# Charlotte-Mecklenburg Planning Department

**SUBJECT:** Administrative Approval for Petition No. 2006-081 and 2015-007

THE VILLAGE AT ROBINSON FARM  
 OFFICE AND RETAIL SPACE  
 PEMBROKE PARTNERS LTD. PARTNERSHIP, CHARLOTTE, NC  
 TECHNICAL DATA SHEET

THE VILLAGE AT ROBINSON FARM  
OFFICE AND RETAIL SPACE  
PEMBROKE PARTNERS LTD. PARTNERSHIP, CHARLOTTE, NC  
ILLUSTRATIVE SITE PLAN

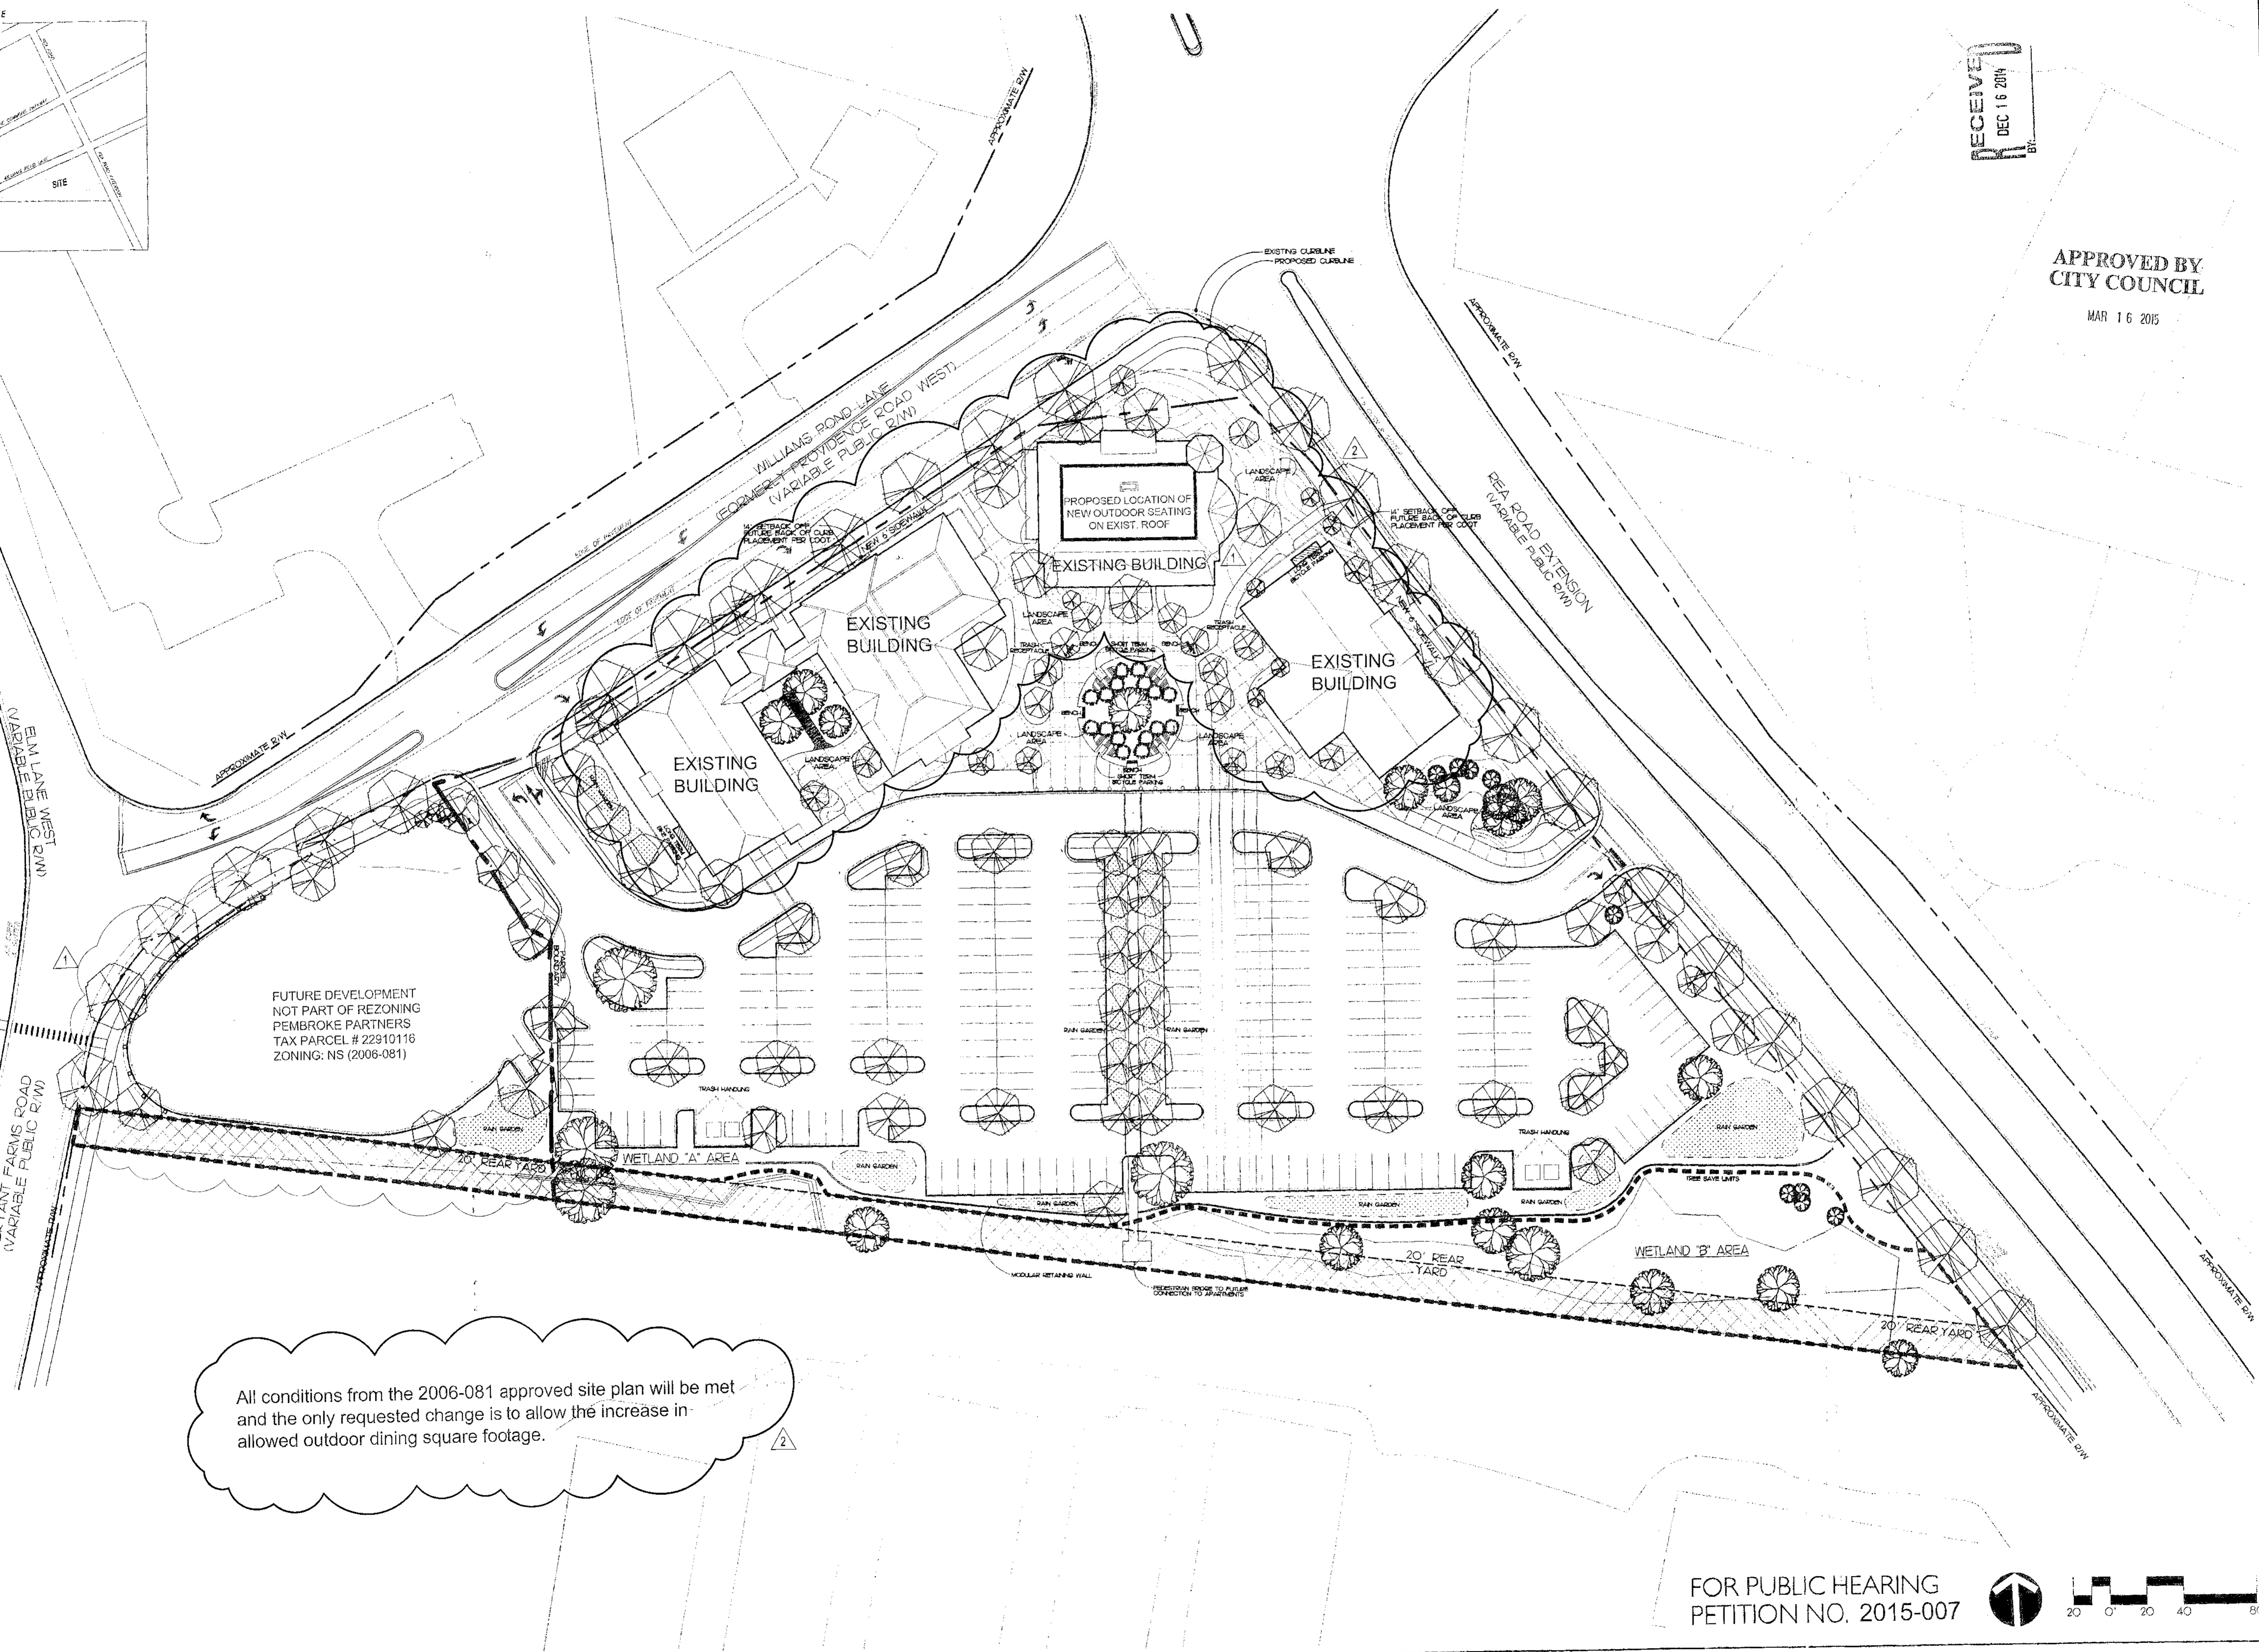
- Location of proposed and existing outdoor seating areas.

Existing Outdoor Seating Restaurants	Proposed Outdoor Seating		Existing Square Footage	Proposed Square Footage	Overall total sq. Feet
Bradshaw's Social House			1,120		
Toast			595		
Lure			600		
Hawthorne's			350		
	Roof Top			2,080	
		Total	2,665	2,080	4,745

- Please note that if any areas not shown will still count toward the allowed outdoor dining square footage. Any future or proposed areas may not be allowed if square footage allotted is already used.
